From: Simon Davis
Sent: 28 November 2013 10:25
To: 'Paul Clarke'
Subject: RE: Hobbs Court Bilsham Road, Yapton, Arundel. Y/59/13/ and Y/60/13/L
Attachments: Hobbs Court, Yapton.doc

**ADC Planning Consultation
Response from the Historic Buildings Adviser**

Application Number	Y/59/13 & Y/60/13/L <del> </del>
Address	Hobbs Court, Yapton
Description	Revisions to Y/3/89, Y/4/89 and Y/60/90
Case Officer	Simon Davis
Site Visit	Previous

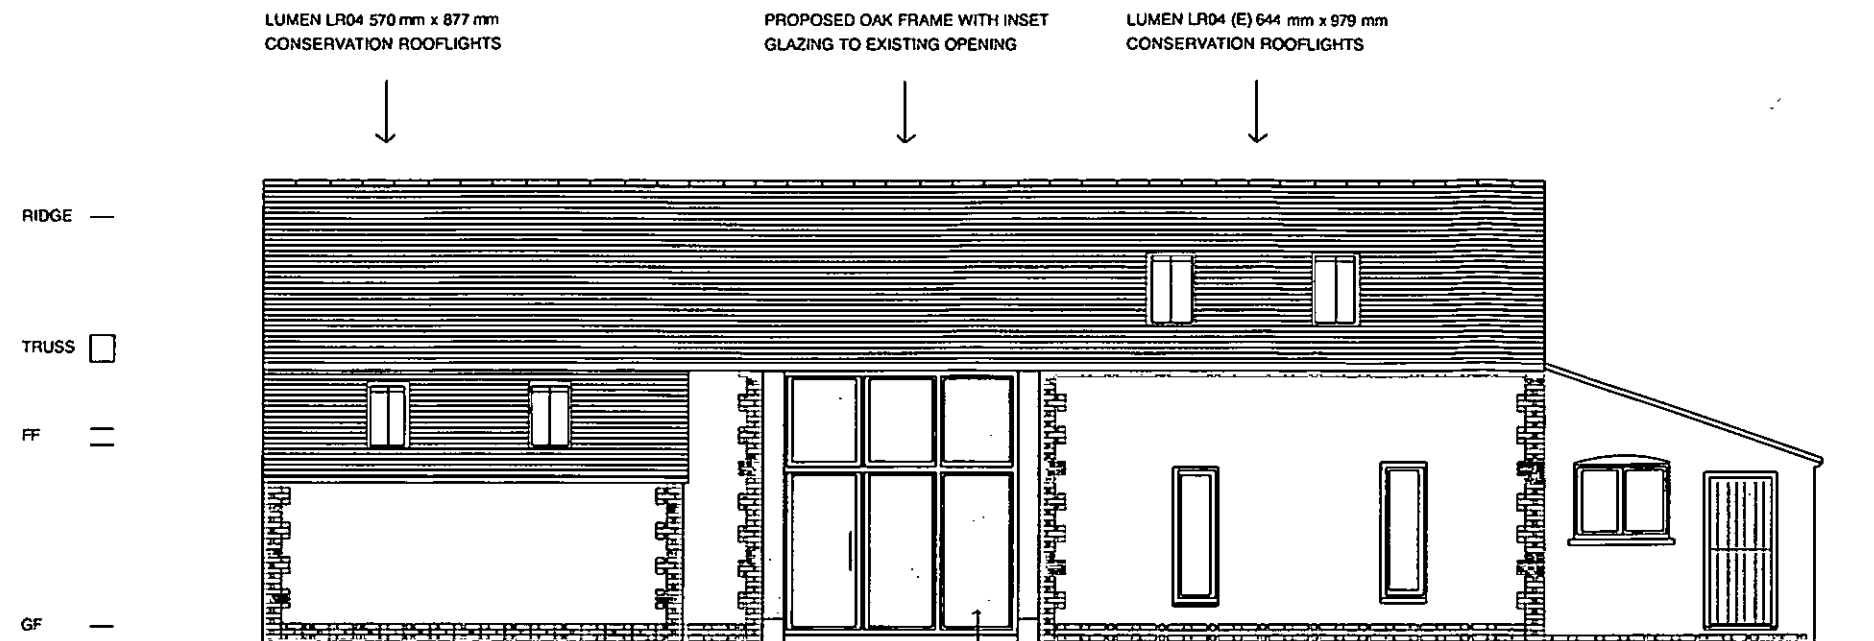
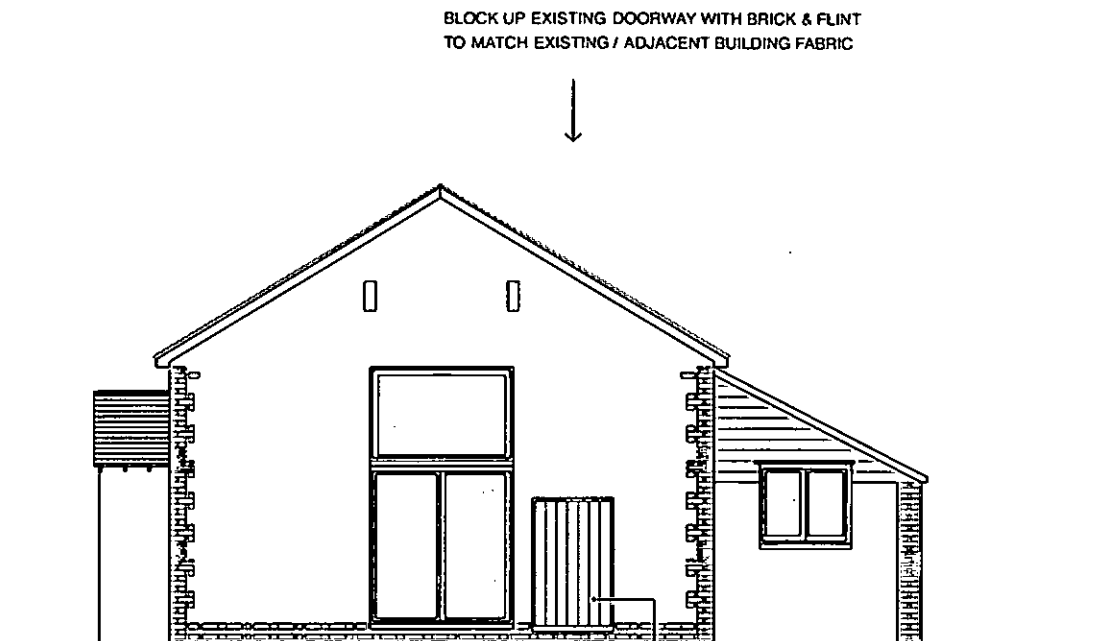
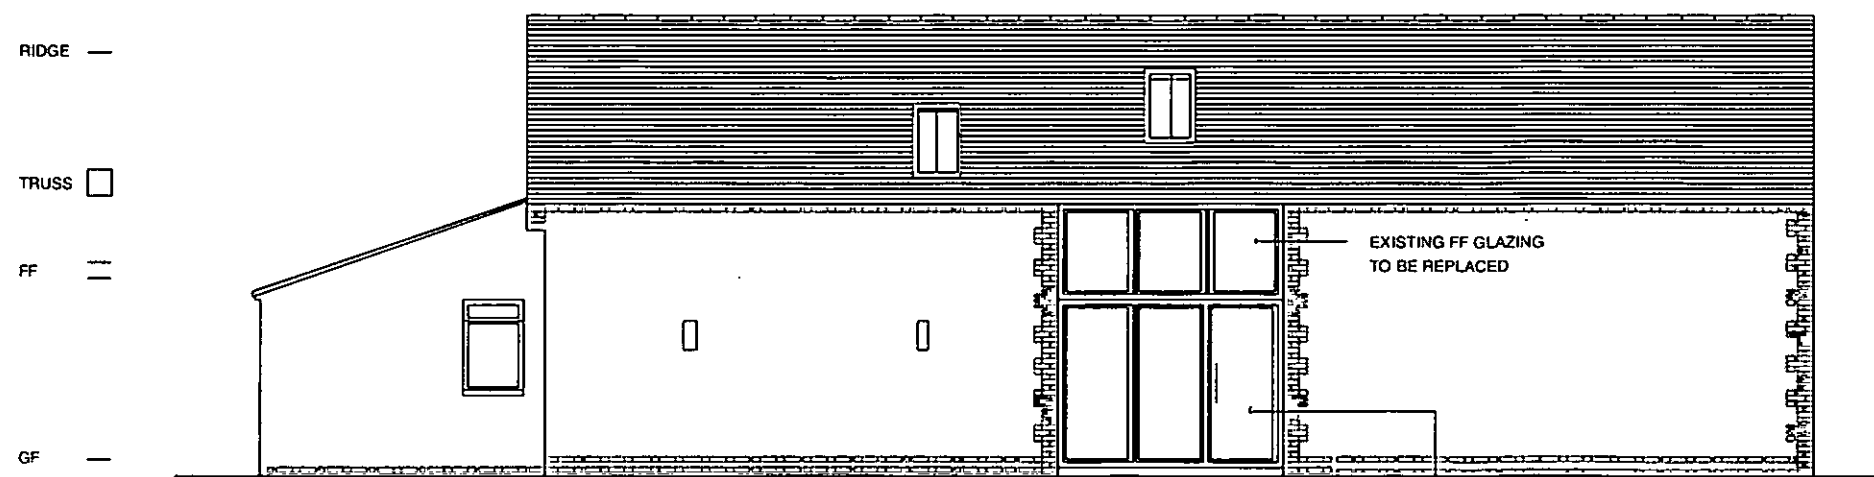
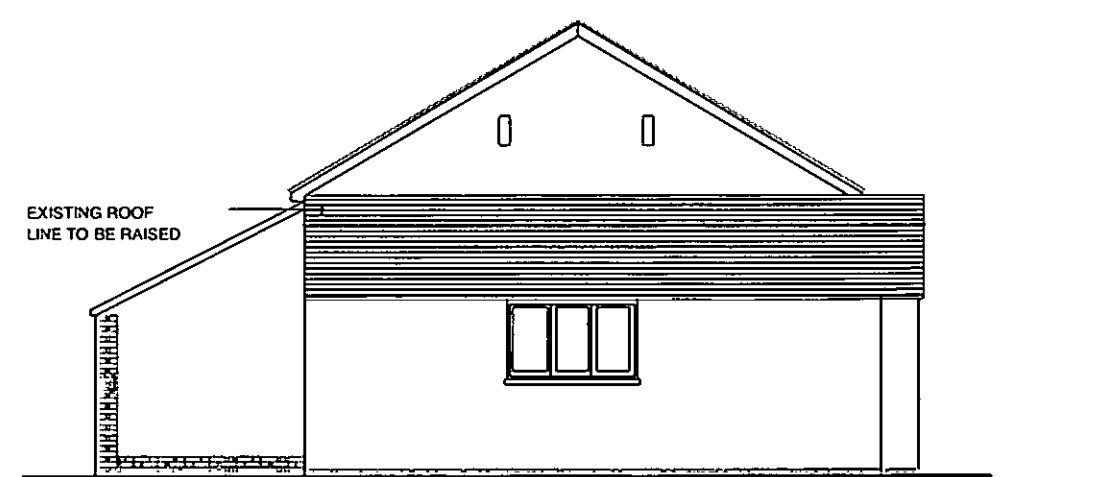
- Staircases in the threshing areas of barns are normally avoided to allow this important space to be expressed more fully. Ideally, the staircase should be located to the side of this space.
- The rooflight to the WC is located in the corner of the roof and as such does not appear sympathetic with the building. Given the low importance of this room, the rooflight should be omitted.
- The rooflight to the study does not appear justified given the level of light here. This should be omitted.
- One of the two rooflights on the front elevation should be removed as this currently appears overly domestic. Two lights are also excessive for the width of the room. If a further light is required, it should be in the rear slope, further to the omission of those proposed (see above).

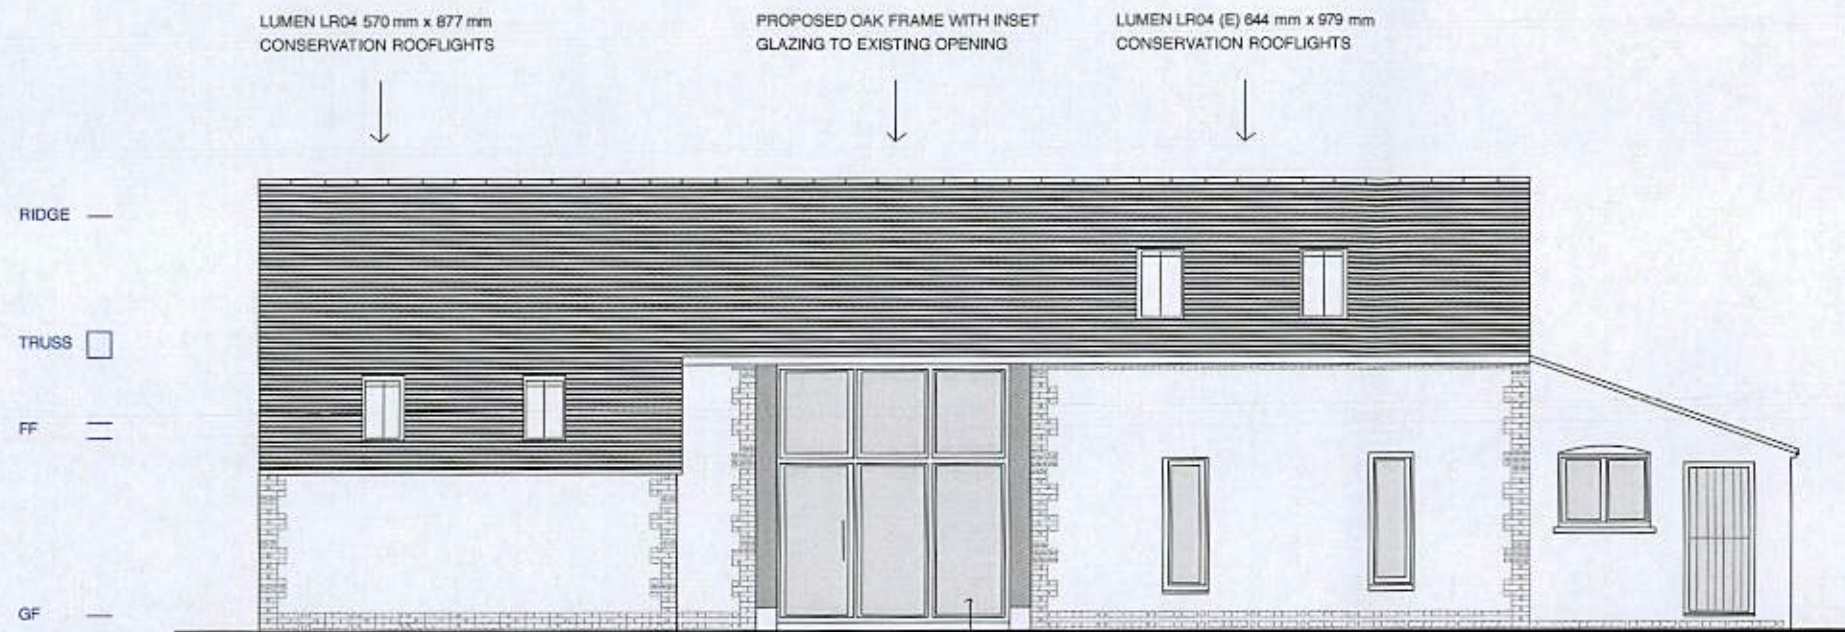
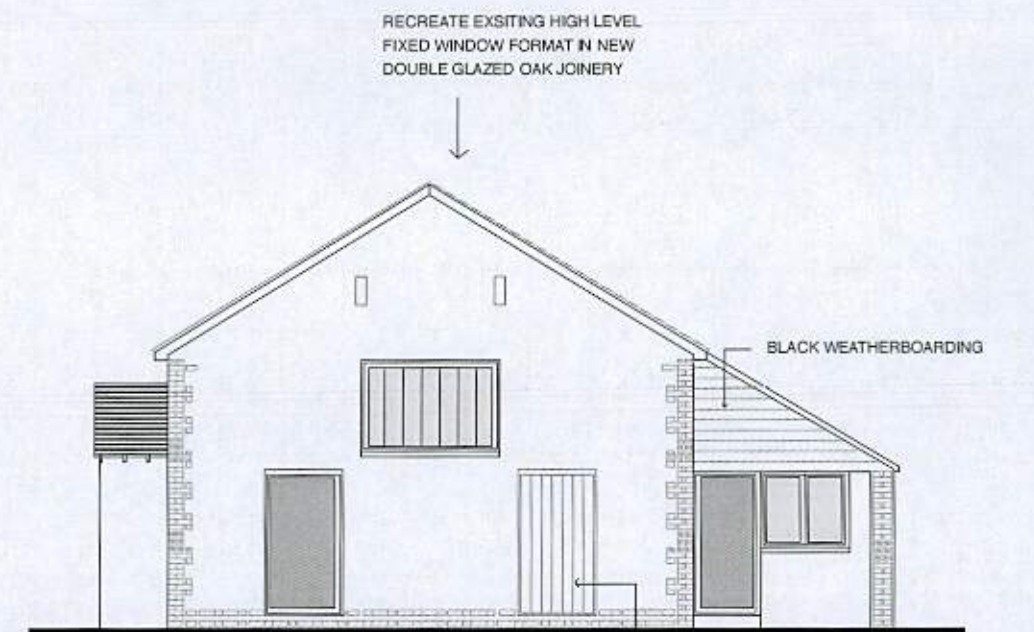
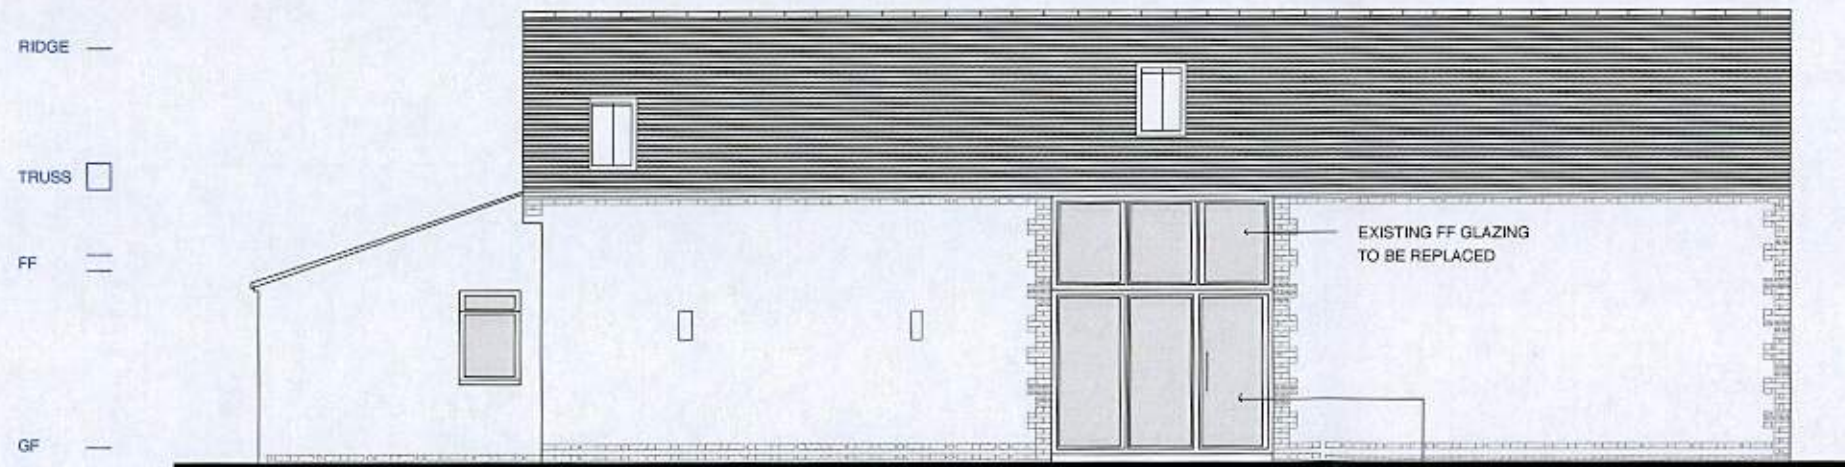
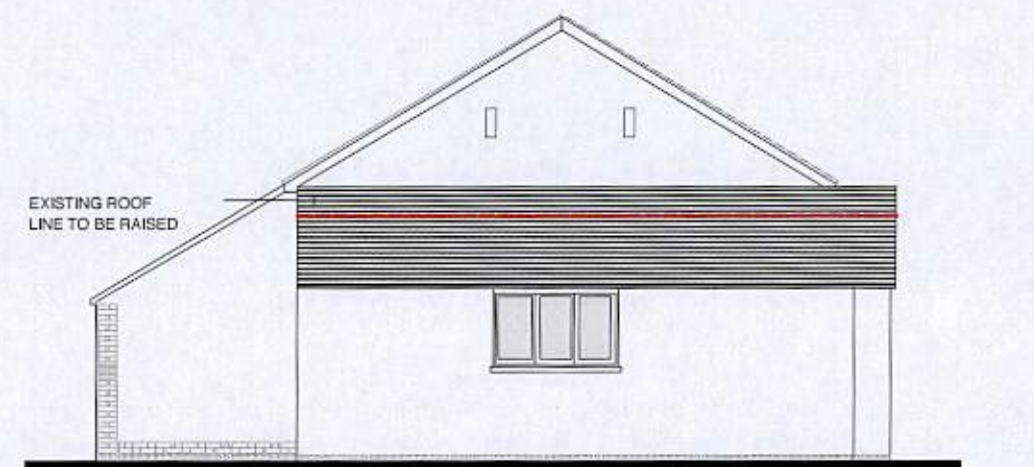
Sorry to be a pain but in confusion with Andrew being on paternity leave the East windows and doors on Tyne barn were agreed to be altered on site to remove the glazed central double doors and replace the high level window like for like in existing location, reposition the timber door mirrored on the elevation and provide glazed door in doors original location. Can these alterations also be included in the alterations to the approval.
Updated plan 002B and elevations 008B attached

I have looked at the differences and on the basis that no new openings are proposed, I consider we can accept these as an amendment. However, given that the determination date is next week, this has to be the last change.
